Extension
5 Camelia Close Littlehampton

Thank you for your internet comments made on 4th April 2017 which has been recorded as **'an objection'** with the comments as follows:

Itemref	Quantity	Title/Name, designation, material, dimension etc	Article No./Reference
Designed by	Checked by	Approved by - date	Date
5 Camilia Close		Proposed Extension	1:50
01		Edition	Sheet

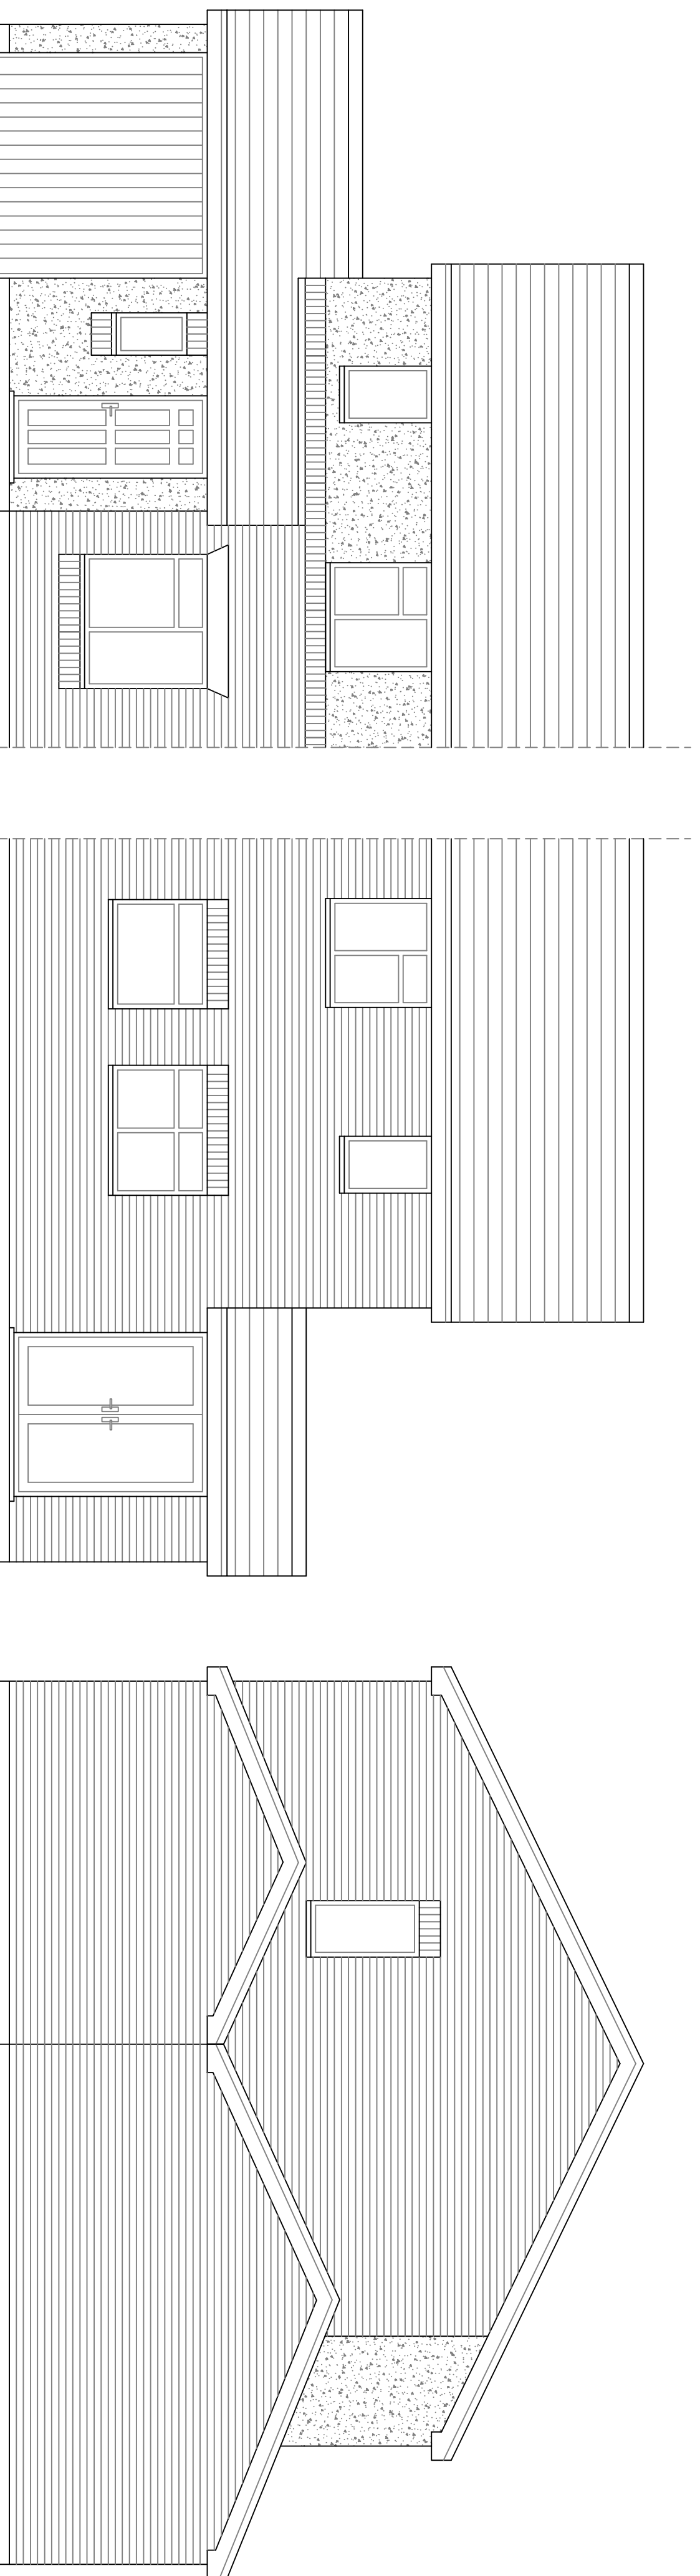
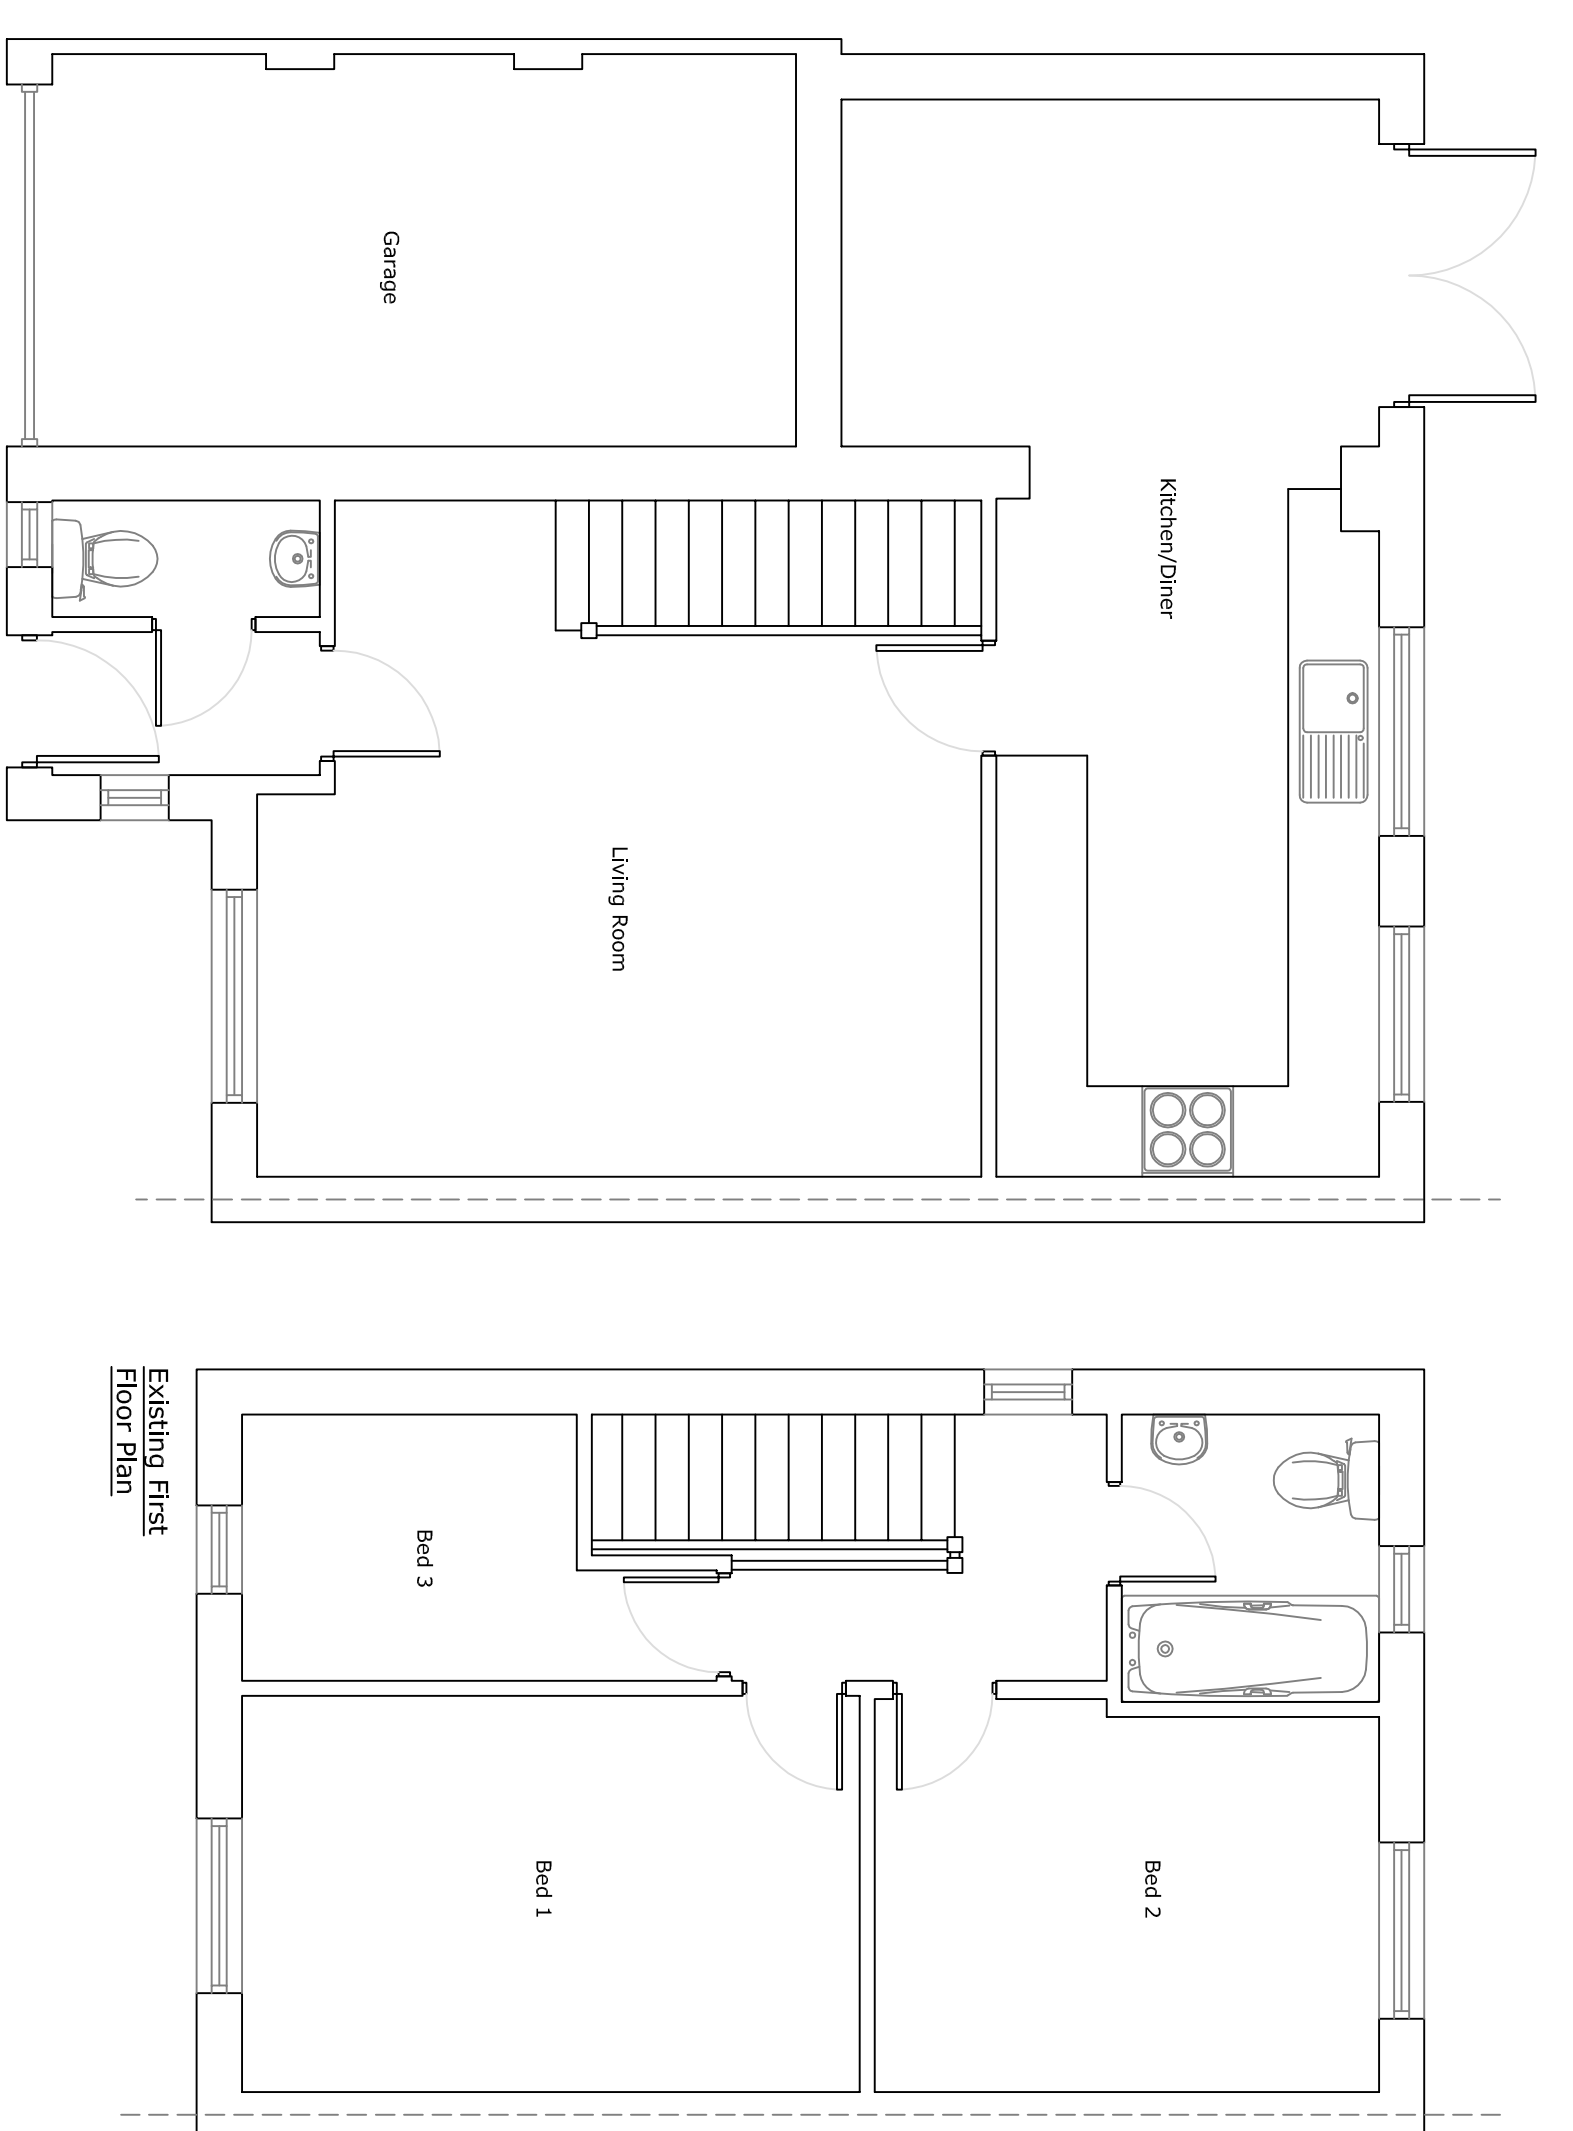
The Town Council's Planning and Transportation Committee considered this matter at its meeting held on Monday 3rd April 2017 and object to the application. It was considered tha the loss of the garage will have an adverse impact on the residential amenity of neighbouring properties by virtue of the fact that it will force more cars to use the street for parking and exacerbate parking problems already experienced by residents in the area.
